My comments are in regard to the proposal for the UNNECESSARY use of Kent Street Lane for construction traffic as detailed in the document Category 7: Other Documents Technical Note – Construction Accesses A-26, A-28, A-61 and A-64 Traffic Management Strategies Date: June 2024 Revision B

Eastern boundary with Kent Street Lane (C-C)

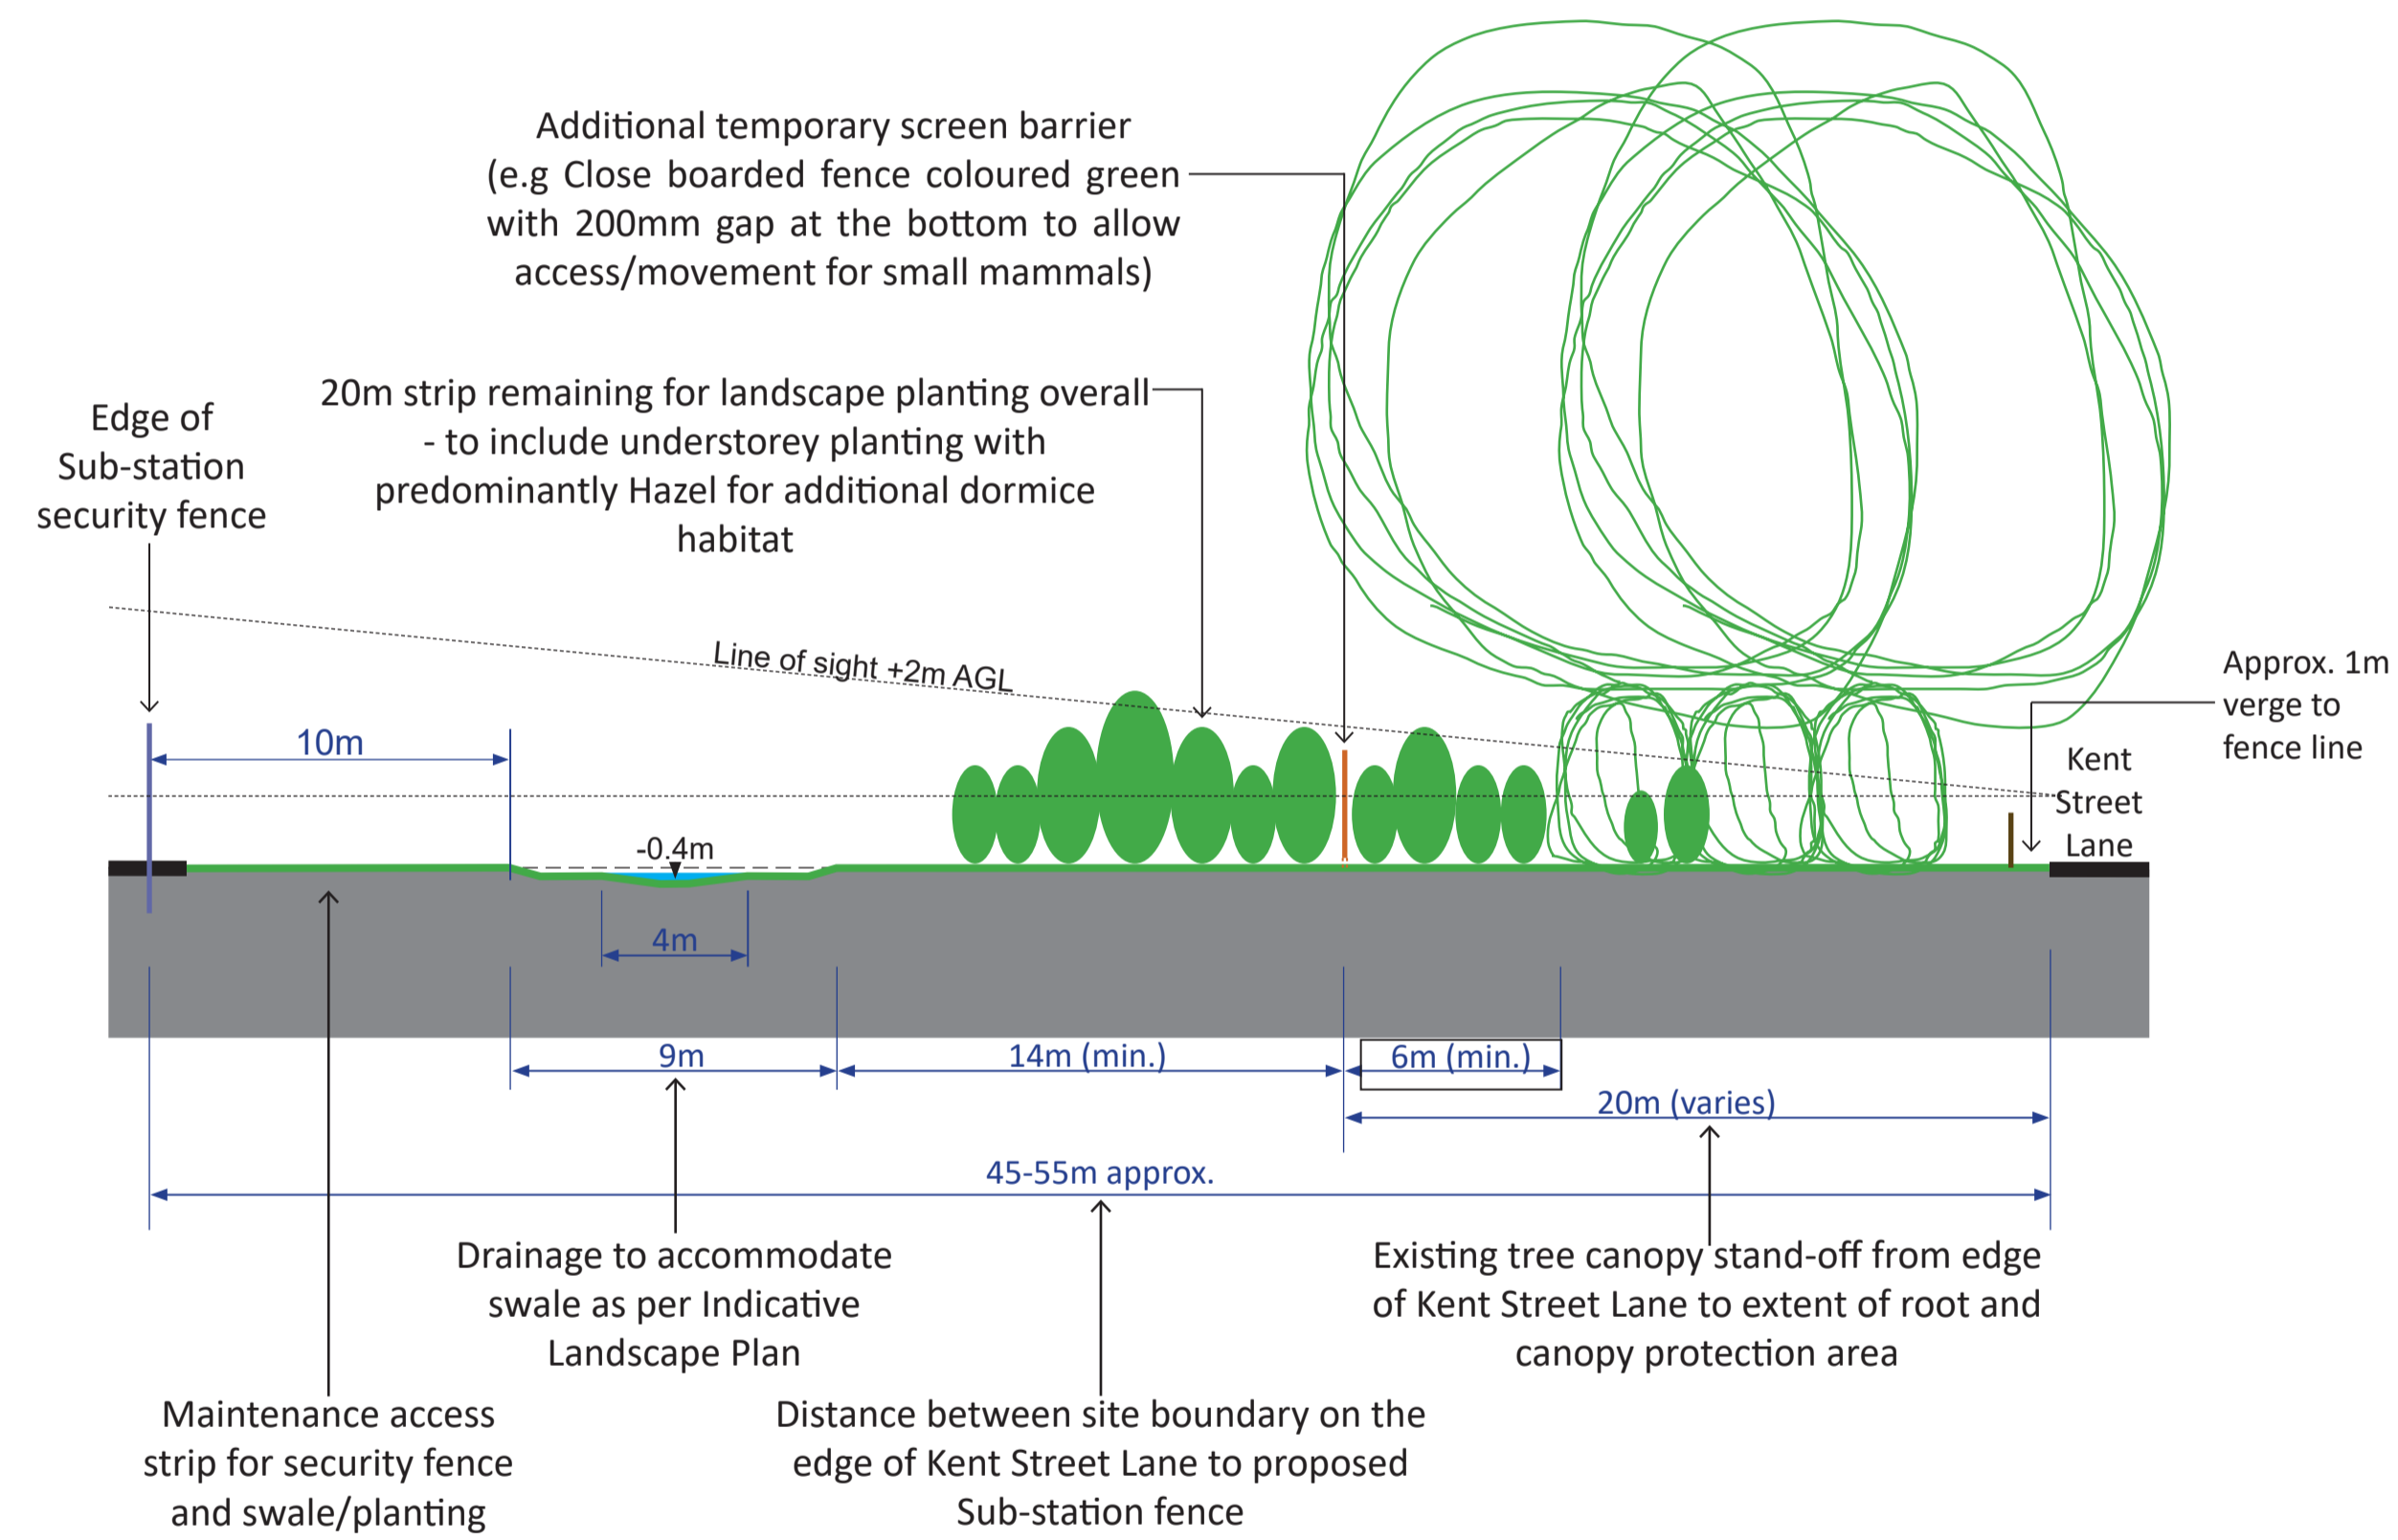
1. In section 3.2.3 the Applicant has failed to include specific reference to Buckhatch Lane Bridleway, which is key to understanding Kent Street's value as a connector for local amenity users. Buckhatch Lane provides the connection for cyclists to the lanes and PROW's going east via Frylands Lane across to Hickstead, and west to Shermanbury and thence the Downs Link. It is also essential for horse exercise, with Buckhatch Lane and then the bridleway to St. Giles, Shermanbury offering the cantering opportunity for horses in the area. Hence the Applicant is understating the impact its proposed use of Kent Street will have on amenity users during construction, as well as the permanent devastation their proposals will have on the long term local character and amenity value of the lane for so many users.

2. The site for the second proposed additional passing bay to the west side of Kent Street, as per section 3.4.9 and diagram 4 on page 252 of Appendix D, is actually a deep, steep-sided, ditch into which a lorry overturned when its non-local driver tried to allow an oncoming vehicle to pass.

3. Section 3.4.12 traffic flow analysis is based upon vehicle journey times of 5 minutes from the compound to Construction Access A61, based on a speed of 20mph. Equestrian users and dog walkers will not travel at 20mph and so journey times will be longer where either type of amenity user is encountered in either direction. Hence in reality it is far more likely that existing users of Kent Street Lane will be impacted than suggested by the Applicant's analysis - and specifically in terms of how long they would be being held back by banksmen at either end of the lane.

4. The proposed management of Pedestrian, Cyclist and Equestrian traffic in section 3.4.15 is noted. However it must be highlighted that the BHS guidance for a minimum 4 metre passing space is not meant in a context where horses are being kettled, with other lane users, for a period of 5 minutes or more, by the banksmen at either end of the lane. Horses are more likely to become nervous and stressed when standing still and feeling in any way constrained for space. Reactions include spinning round, walking backwards and possible rearing - all of which pose risk of significant injury to bystanding cyclists or dogwalkers. Much more space than that afforded by a single track lane, with ditches, would be required to safely contain horses, cyclists, pedestrians, dogs, car traffic and farm vehicles together. Additionally it must be confirmed how the banksmen will hold equestrians and cyclists back, and in what space, at the end of Picts Lane while an HGV is coming northbound up Kent Street.
